Town & Country Planning Act 1990 (as amended)
Town and Country Planning (Development Management Procedure) (England) Order 2015
Approval of details reserved by condition imposed under BR/281/18/PL relating to conditions 3-
Arboricultural meeting, 6-Construction Management Plan, 7-landscape scheme, 8-colour scheme of
materials and/or finishes, 9-new screen walls and/or fences, 10-covered and secure cycle parking
spaces, 12-dustbin enclosures, 13-electric vehicle charging & 14-decentralised, renewable and low
carbon energy supply systems.
99 Victoria Drive Bognor Regis PO21 2DZ

Condition Number 10

Arun District Council have decided to **APPROVE details reserved by this condition**

PROPOSED CYCLE STORAGE

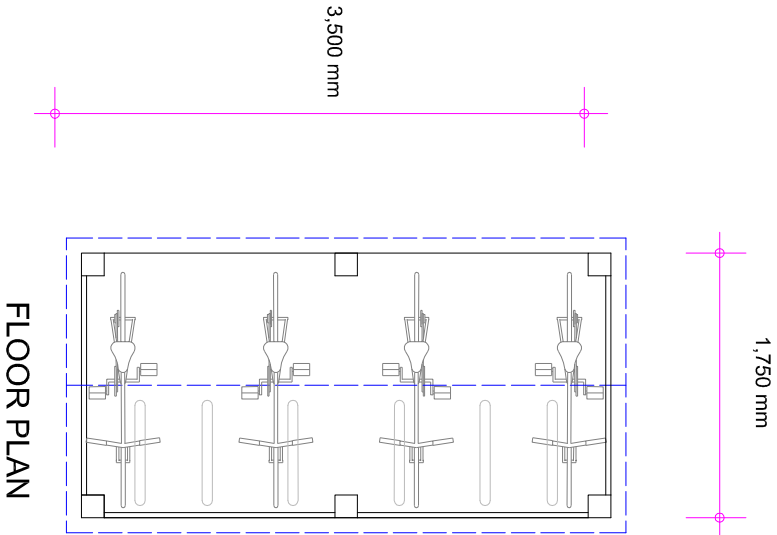
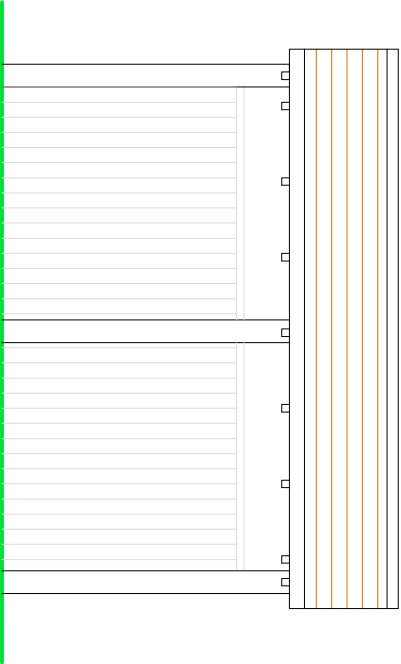
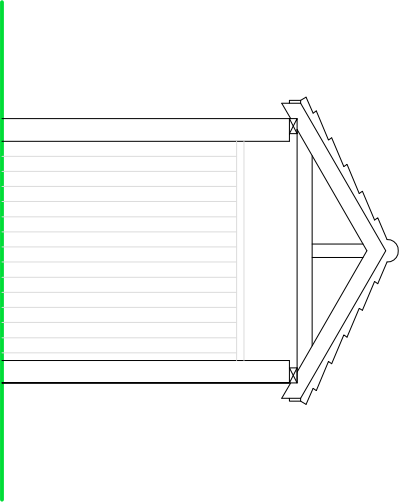
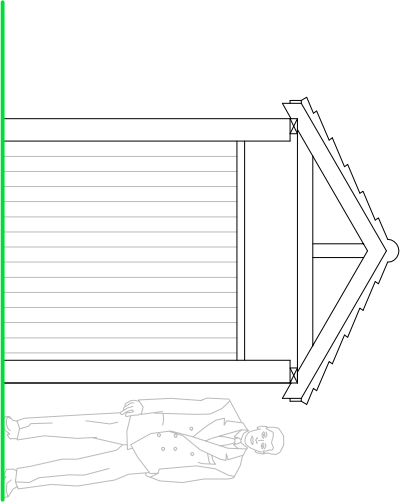
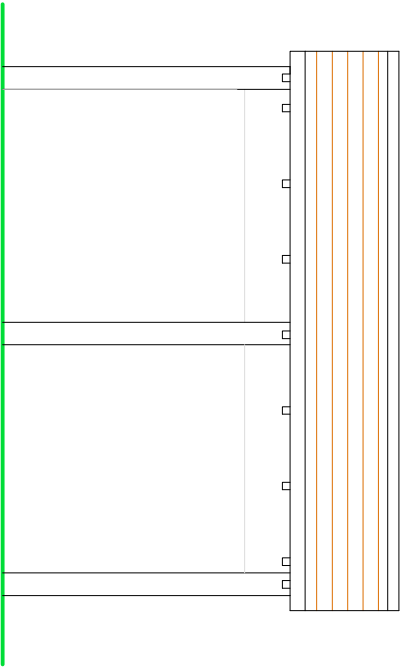
West Sussex County Council Highways have been consulted on the proposed covered and secure cycle stores and submitted site plan, demonstrating the location of 6 hoop style stands provided within a secure area and they are considered to meet the aims and requirements of the condition.

Therefore, the condition is fully discharged insofar as the submission of details relates and on the understanding that the covered cycle stores will be permanently retained in good working condition.
